**Block 4B Central Park Adaptive Reuse (SSD-9374 and MP06_0171 MOD 16)
Request for Additional Information**

I refer to the assessment for the above applications to modify the Central Park Concept Plan and for development consent for Block 4B at Central Park.

Attachment 1

PUBLIC DOMAIN

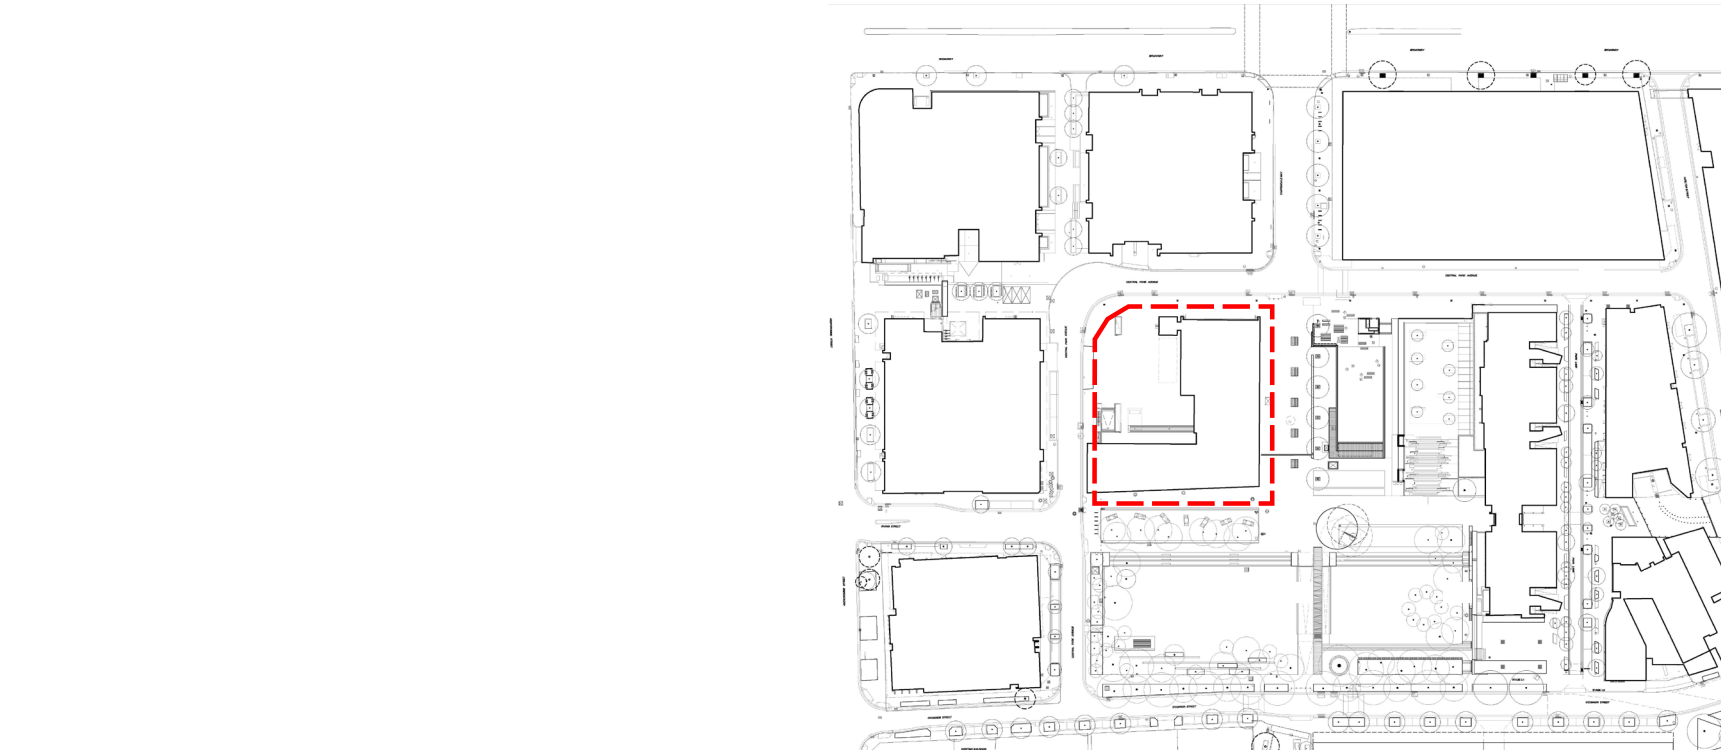
- ii. The response indicates the pedestrian kerb ramps can be deleted, however they are shown on the submitted Landscape Plan in Attachment 4.
 - iii. While the new vehicle crossover is identified on the Landscape Plan in attachment 4, the following additional information should be provided:

- i. turning circles, as requested by Council
 - ii. proposed parking location of a vehicle in the forecourt and how this arrangement will be managed i.e. management of reversing vehicles in a pedestrian area, time of operation, responsibility for removal of bollards.

- h. Attachment 4 - Public Domain Plan – confirm the area of the forecourt as the foyer has been removed.

Project No.	Drawing No.	Revision
17007	DA 1101	E

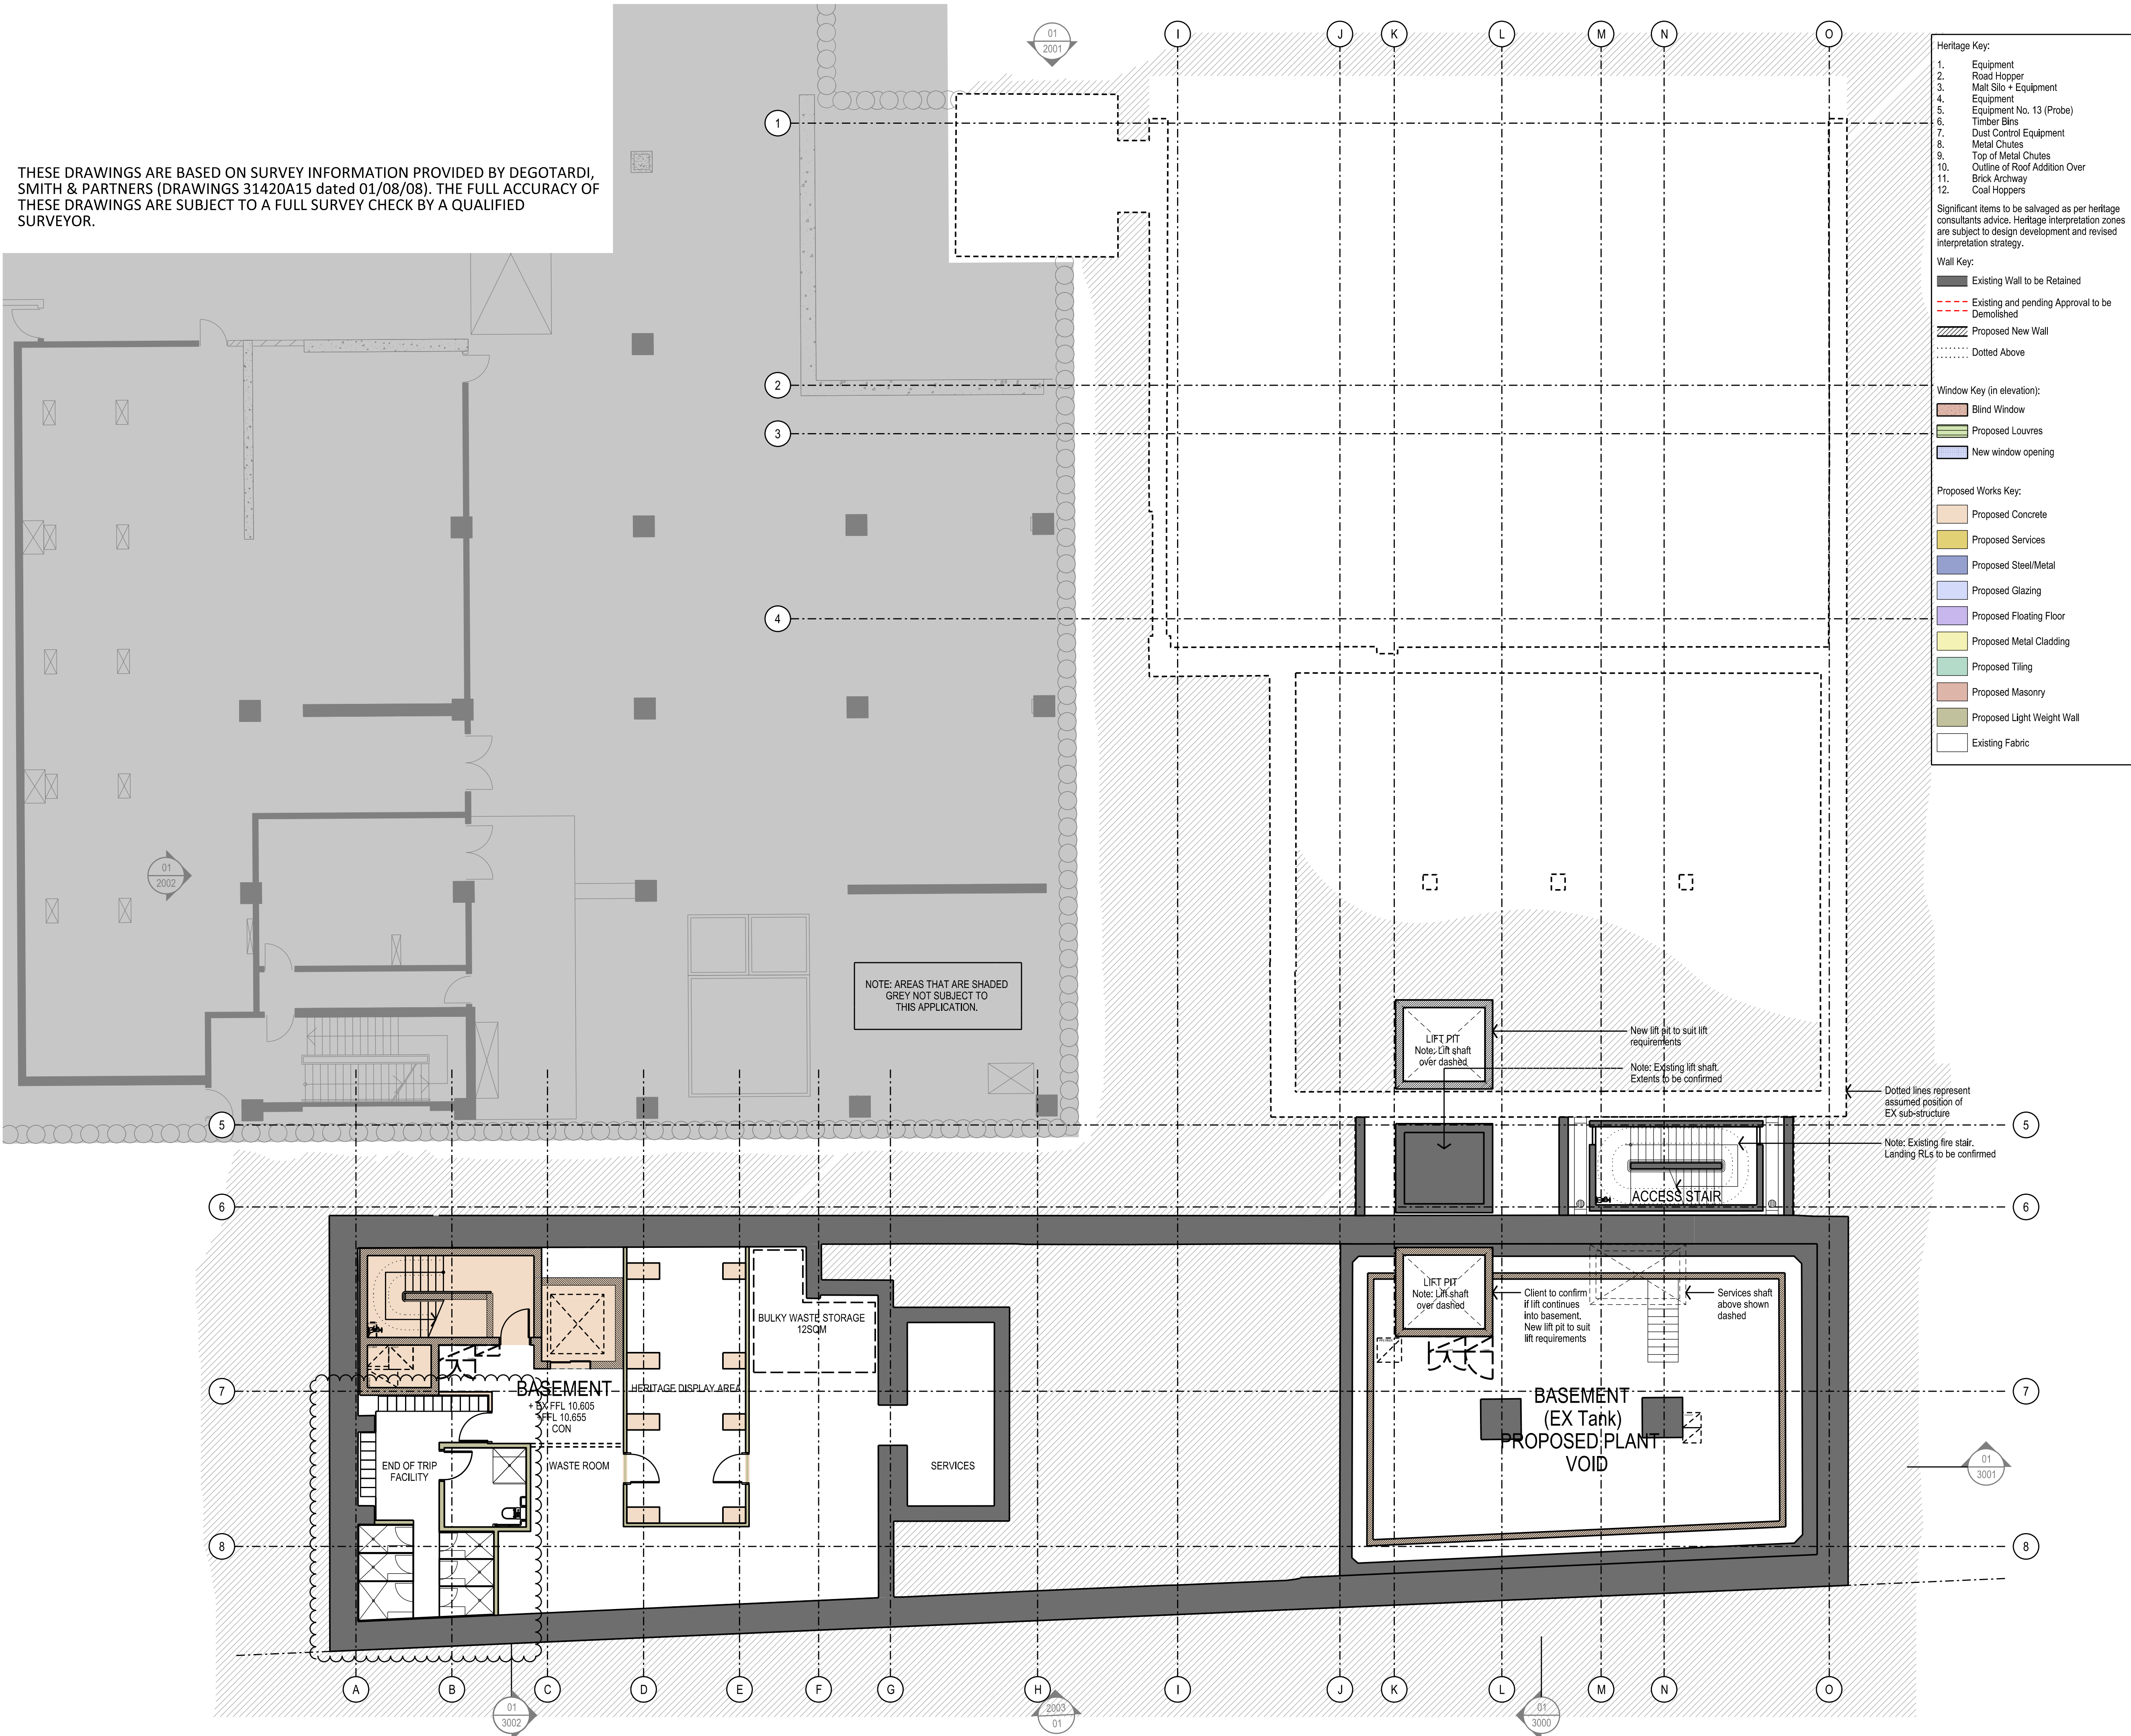
- iii. Basement 1 floor plan, DA 1101, issue E, appears to indicate access to the heritage display area is through the waste room. Please clarify.
- g. Item 9 Public Domain:
